KITTITAS COUNTY COMMUNITY DEVELOPMENT SERVICES

Re: The Grove Re-Zone Application

After reviewing "The Grove" re-zone application, I have the following conditions:

Revised site Plan July 7, 2006

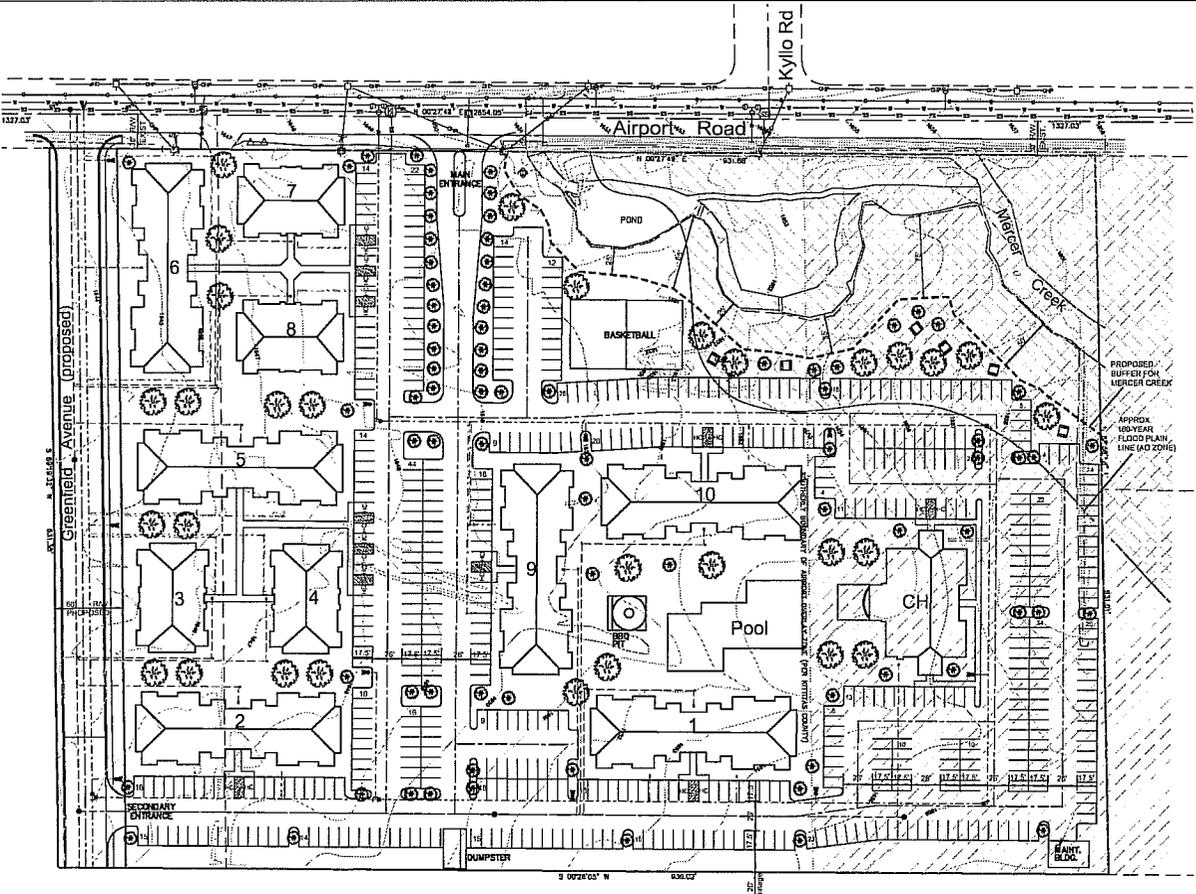
- Fire apparatus access roads shall be a minimum of 26 feet, aside from parking areas.
- There may be no more than 250' spacing between fire hydrants.
- "No parking: fire lane" signs must be posted in front of the proposed volleyball and basketball courts, in addition to the main and secondary entrances. The signs must comply with IFC Appendix D.
- The southeast corner of the proposed development does not meet the minimum requirements for fire apparatus access.
- Additional fire hydrants are necessary on the south and southwest side of the complex.
